MEMORANDUM

DATE: April 23, 2022

SUBJECT: **On-Call Contract #17-067H-1; PO # 8115428**
Traffic Impact Study Reviews
Task Order #3: Flying Horse North Sketch Plan TIS Review

FLYING HORSE NORTH SKETCH PLAN
SKETCH PLAN DRAWING

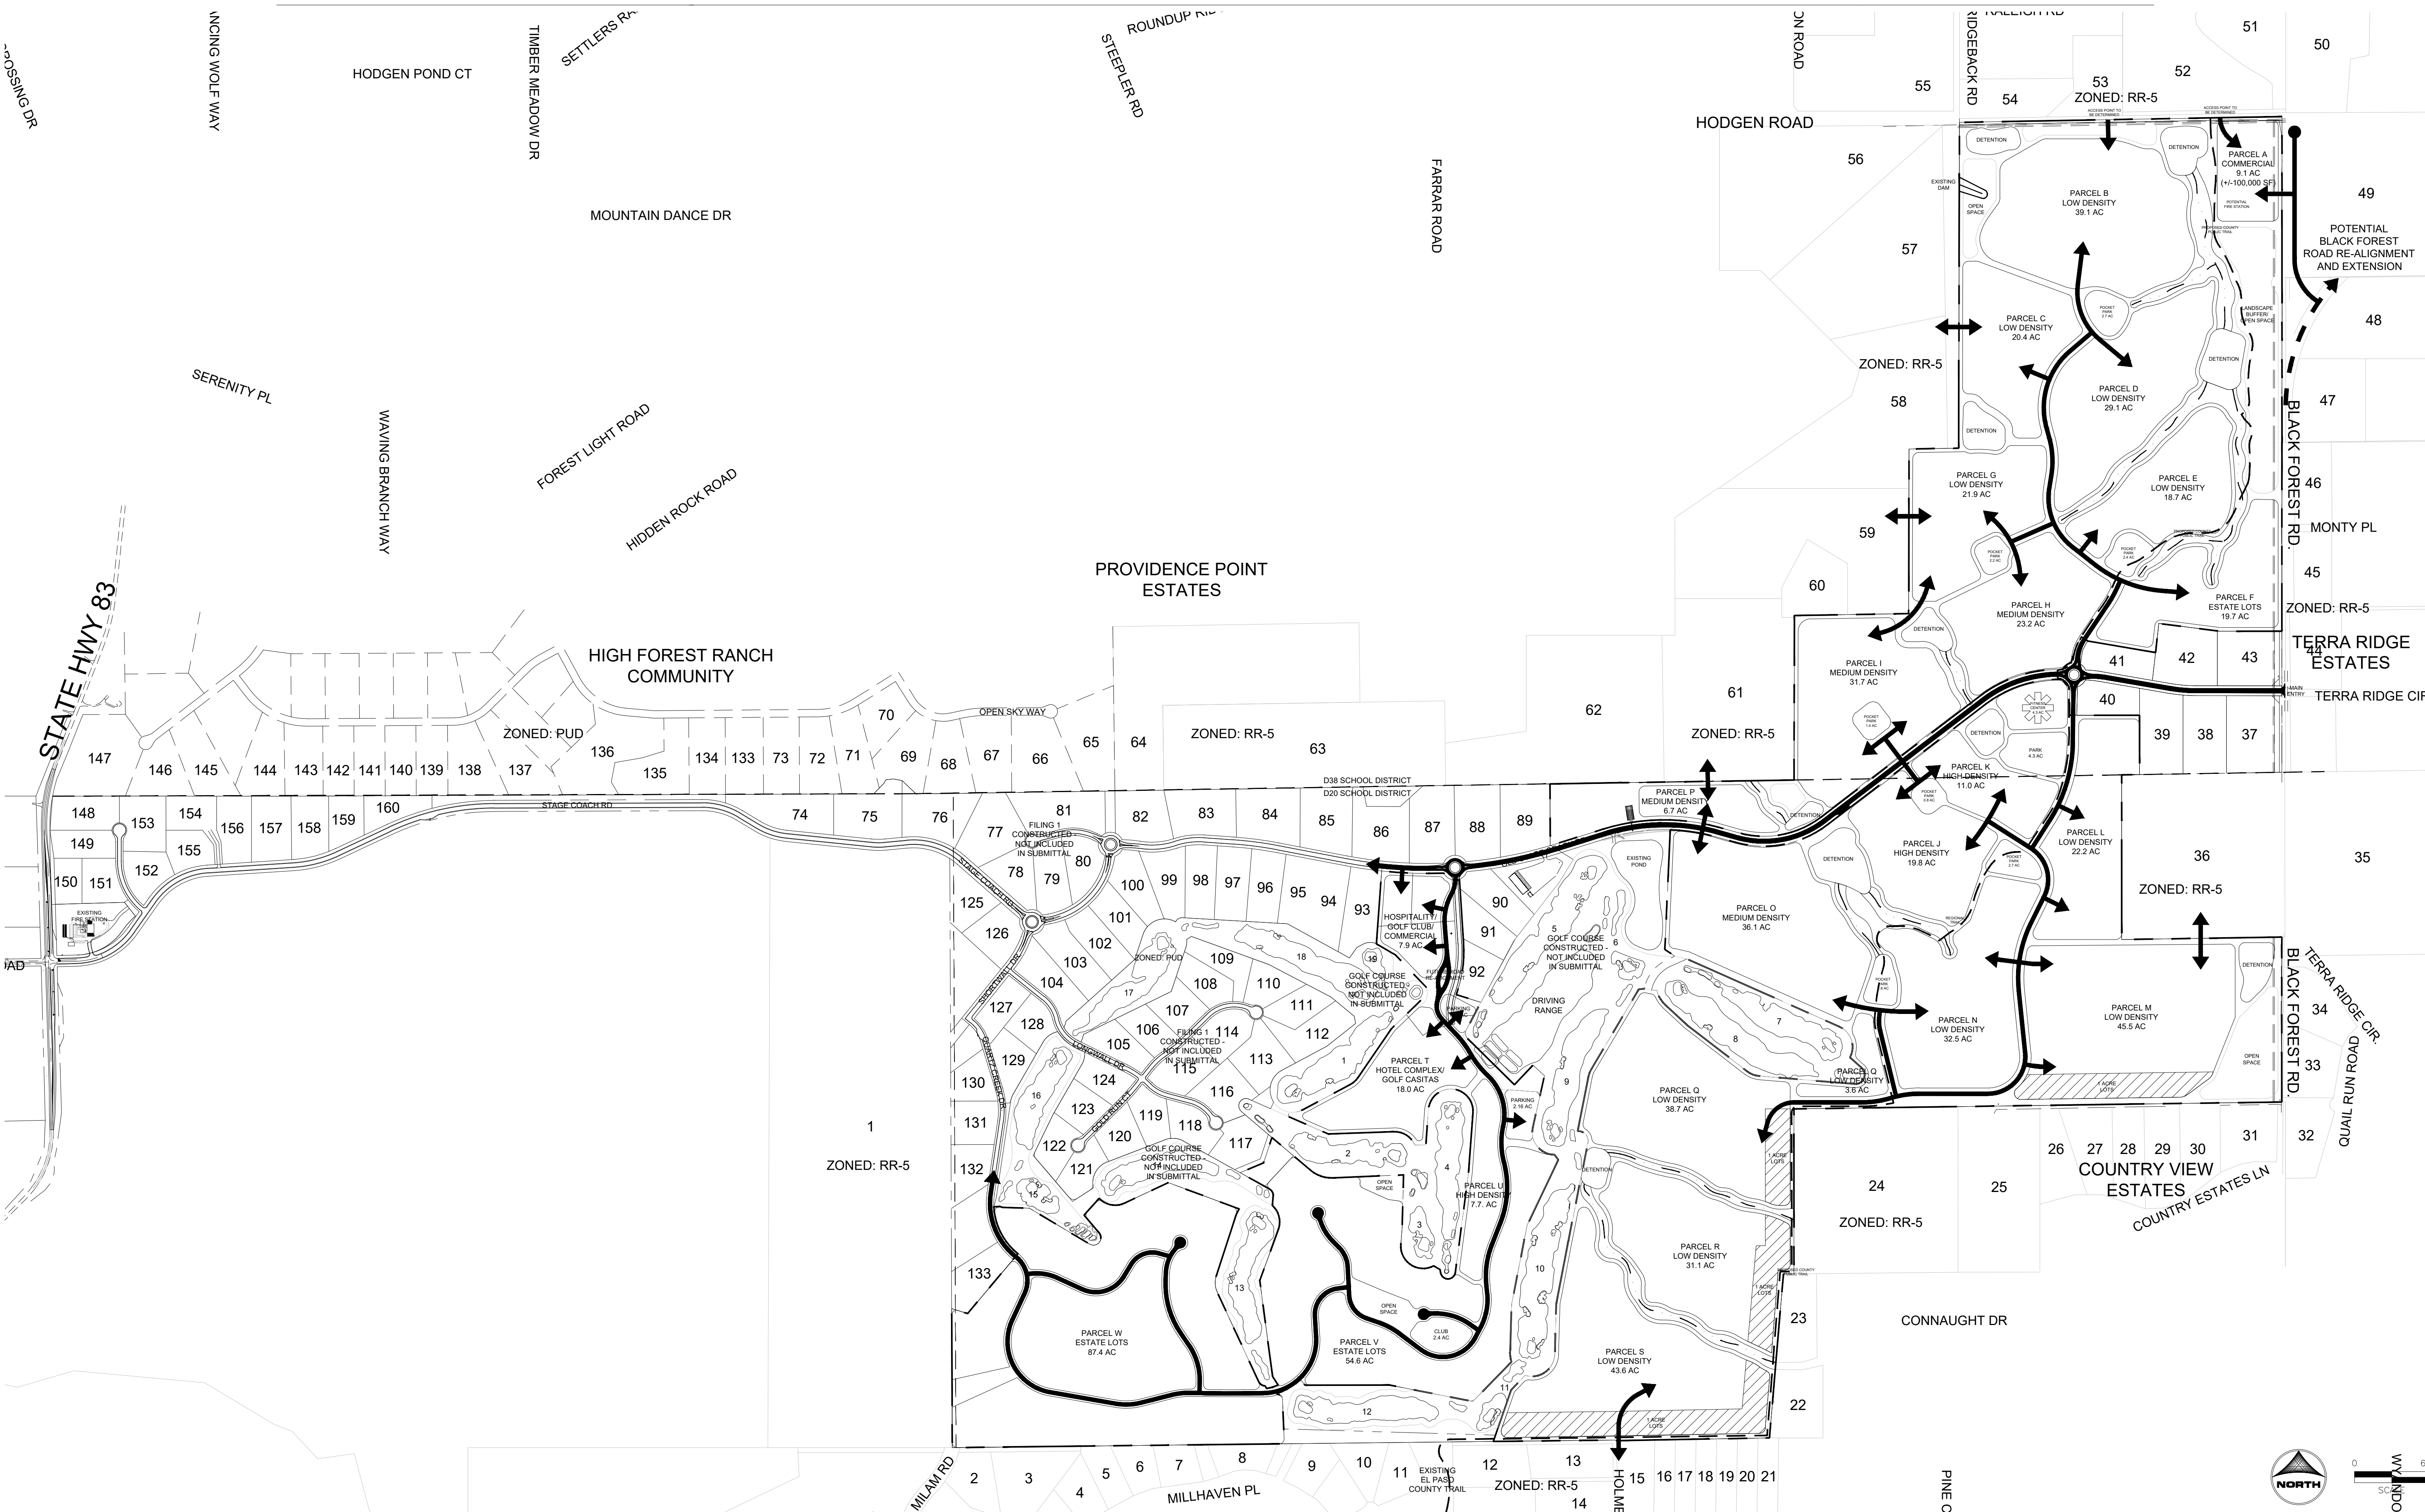
7. There are several conceptual site access points shown on Sketch Plan Sheets 2 and 3 that appear to connect the study area to other subdivisions, including a connection to Holmes Road on the south and Providence Point Estates on the north. Although the TIS assumption that most Flying Horse access would be provided by Old Stagecoach Road is reasonable, these secondary connections should be evaluated in the TIS. This is particularly important for Parcels Q, R and S.
